# MORGAN AND MORECAMBE OFFSHORE WIND FARMS: TRANSMISSION ASSETS

## Public Rights of Way Plan

Document reference: B13/F07  
Rev: F08  
29 October 2025

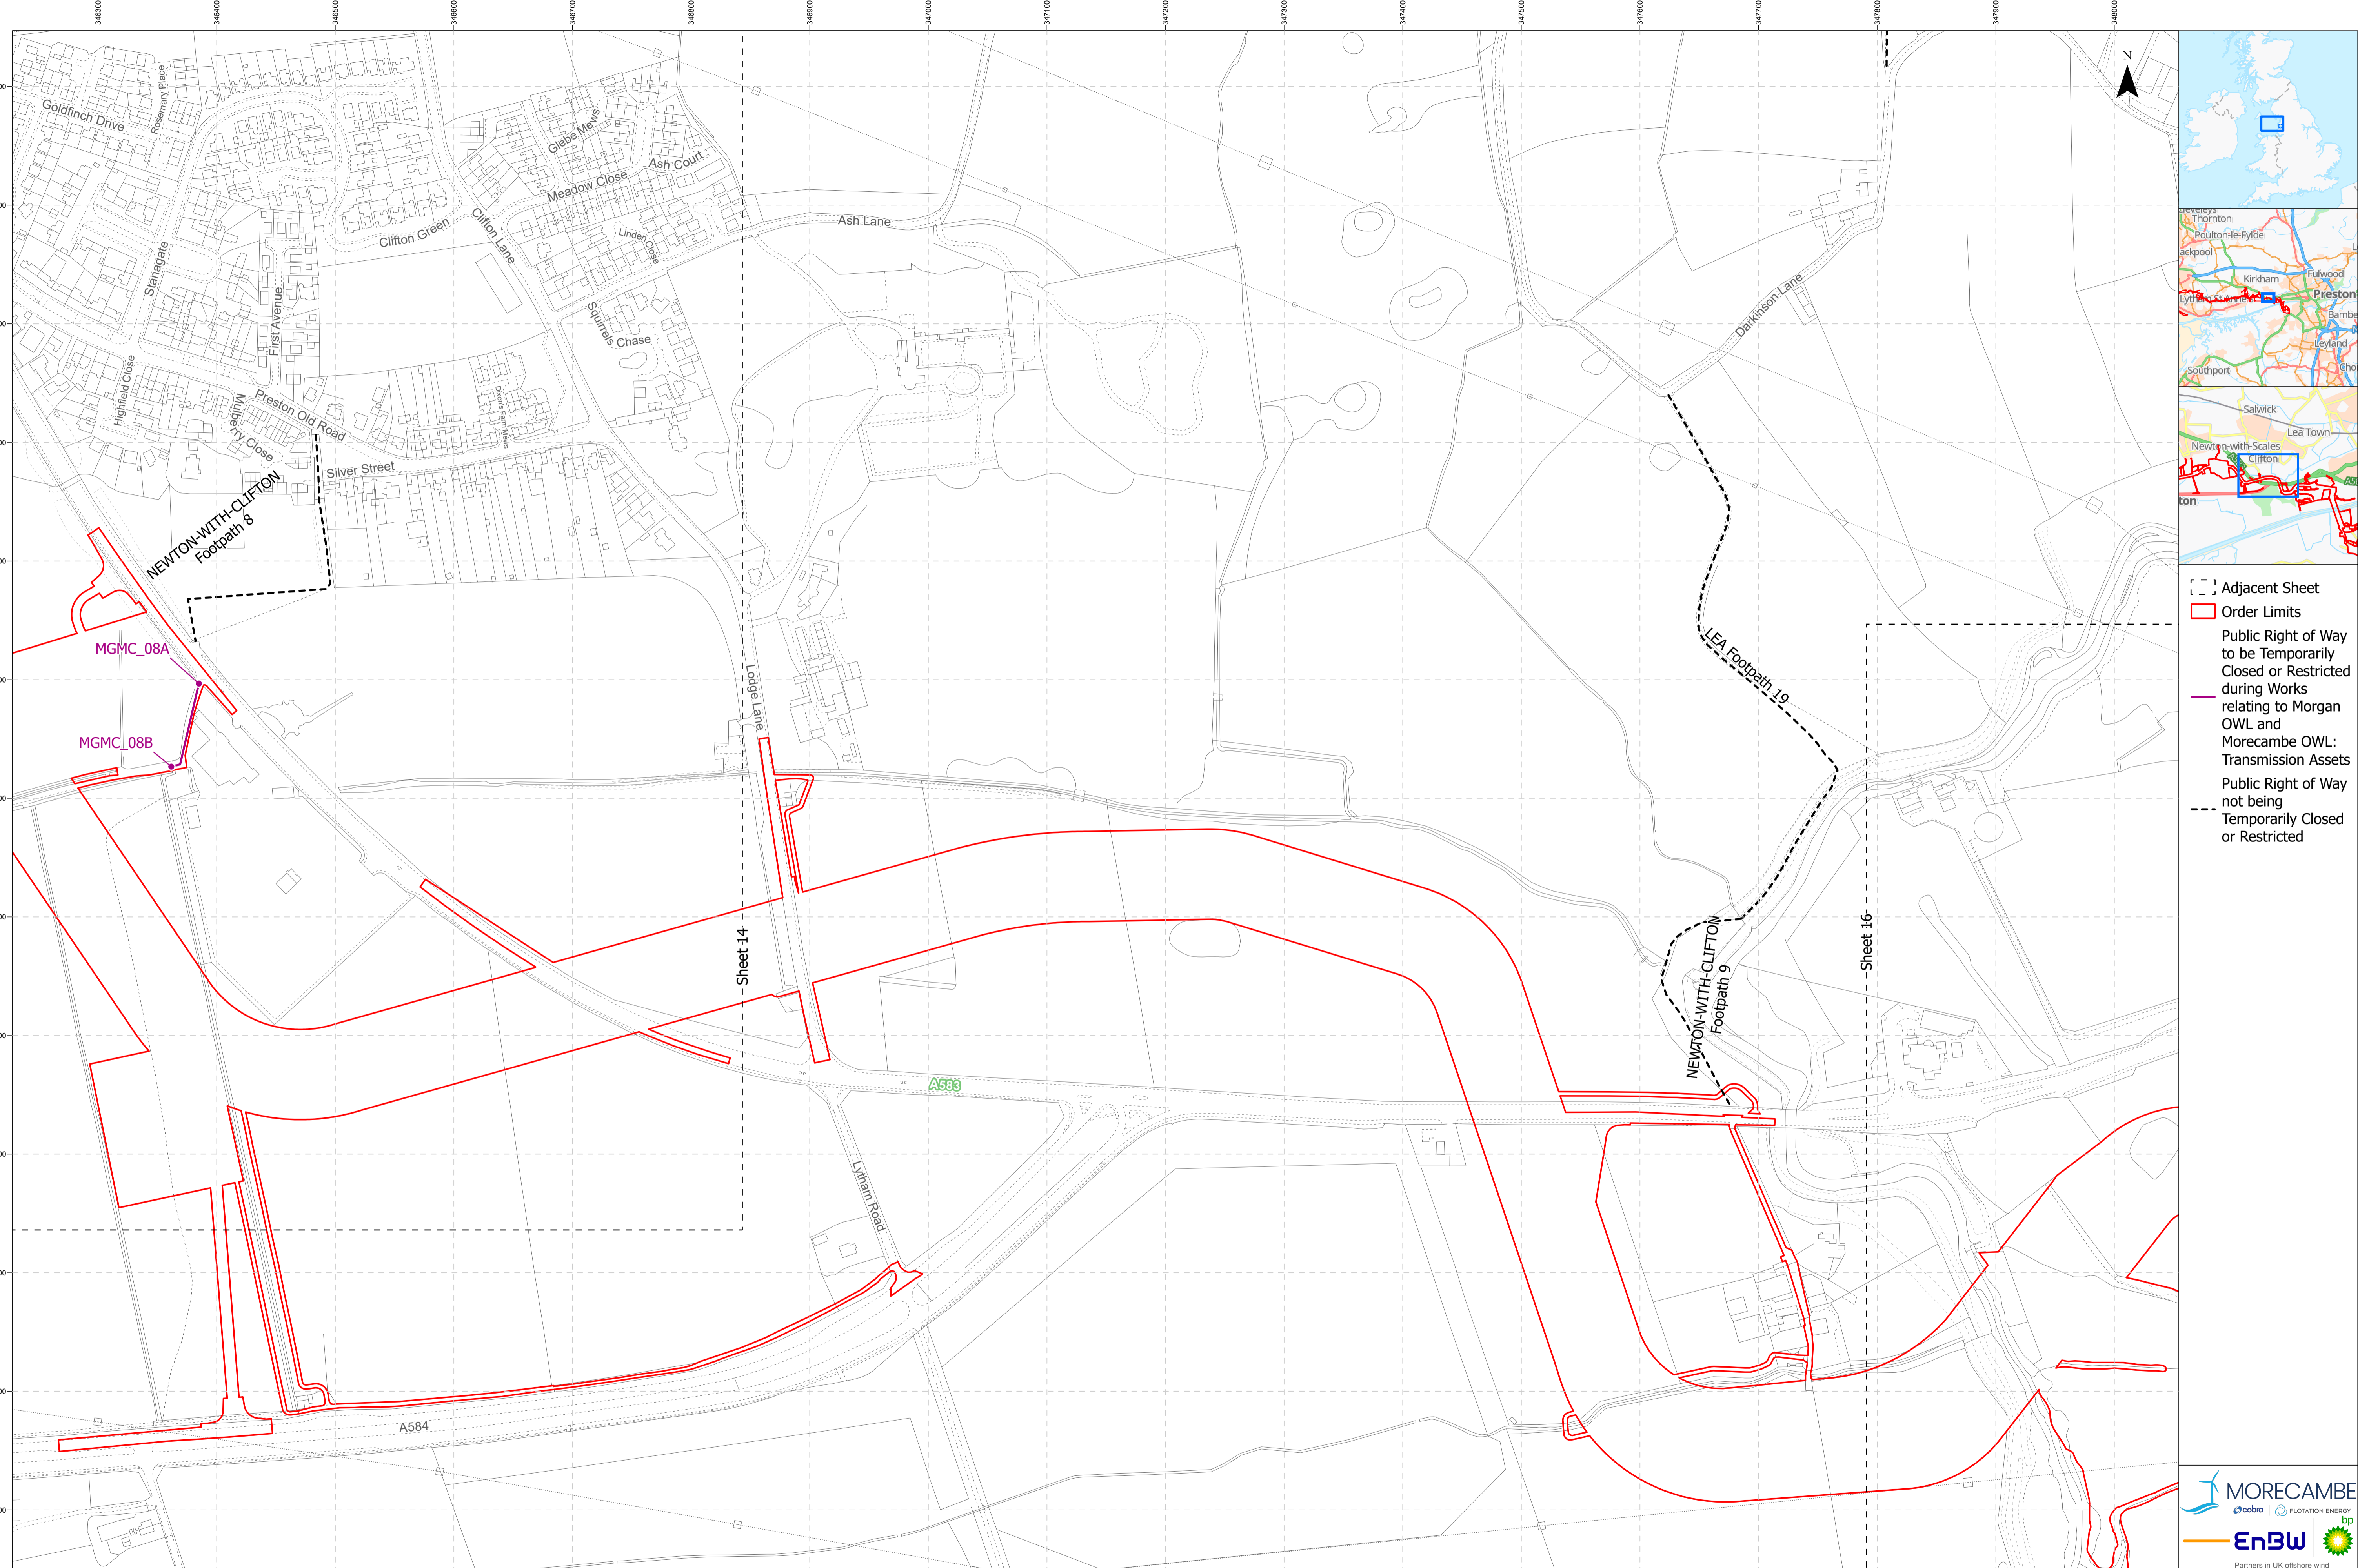
Sheet Number	Change requested by	Change Made	Reason for Change	Revision	Submission deadline
12	The Applicants	The identification and addition of Public Right of Way (PRoW) between MG_14A and MG_14B	A review of the PRoWs which intersect with the Order Limits identified that a section of Bridleway 5-5 BW 16 had previously been omitted from the document.	F02	S51 advice update
12	The Applicants	The identification and addition of Public Right of Way (PRoW) between MG_15A and MG_15B	A review of the PRoWs which intersect with the Order Limits identified that a section of Bridleway 5-5 BW 16 had previously been omitted from the document.	F02	S51 advice update
18	The Applicants	The identification and addition PRoW between MGMC_15A and MGMC_15B	A review of the PRoWs which intersect with the Order Limits identified that PRoW 7-9 FP 5 had previously been omitted from the document.	F02	S51 advice update
18	The Applicants	The identification and addition of PRoW between MGMC_16A and MGMC_16B	A review of the PRoWs which intersect with the Order Limits identified that PRoW PRoW 7-9 FP 7 had previously been omitted from the document.	F02	S51 advice update

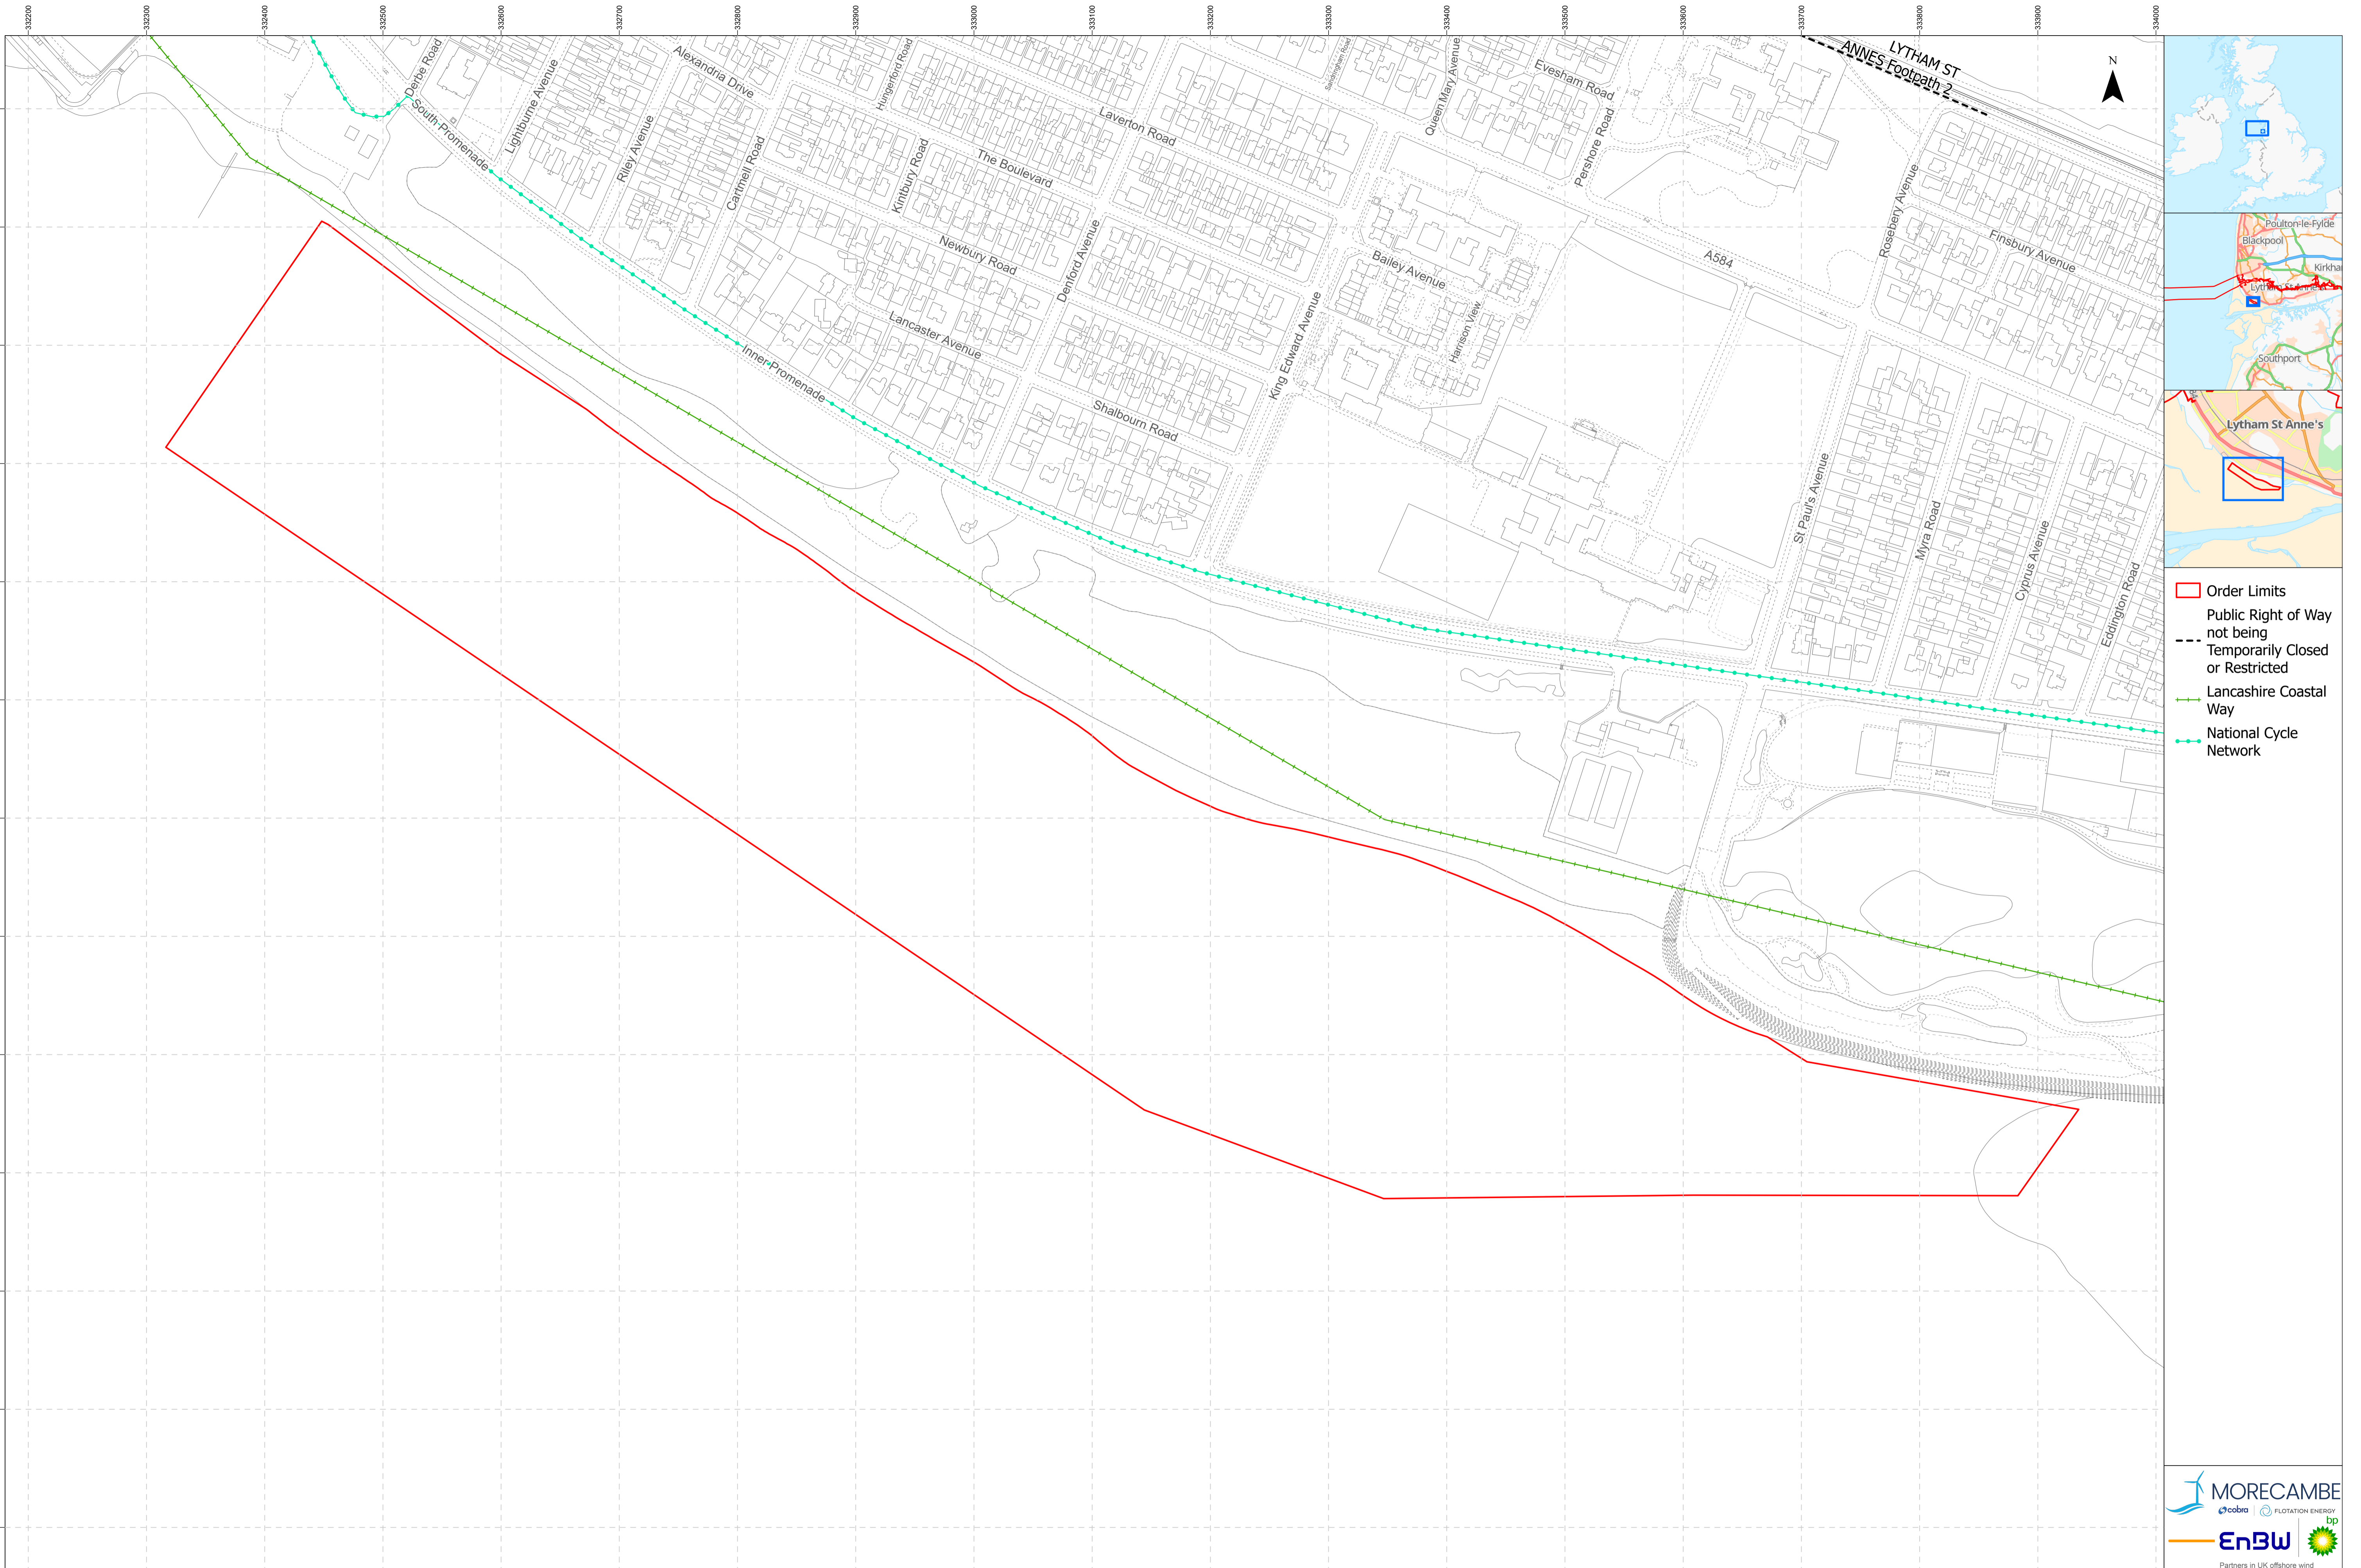
15	Lancashire County Council	The identification and addition of PRoWs between MG_KC_01_A and MG_KC_01_B, MG_KC_02_A and MG_KC_02_B, MGMC_KC_01_A and MGMC_KC_01_B, MC_KC_01_A and MC_KC_01_B, and; MC_KC_02_A and MC_KC_02_B.	These amendments have been made as a result of points raised by the Public Right of Way officer at Lancashire County Council regarding the new King Charles III England Coastal Path. .	F03	Deadline 3
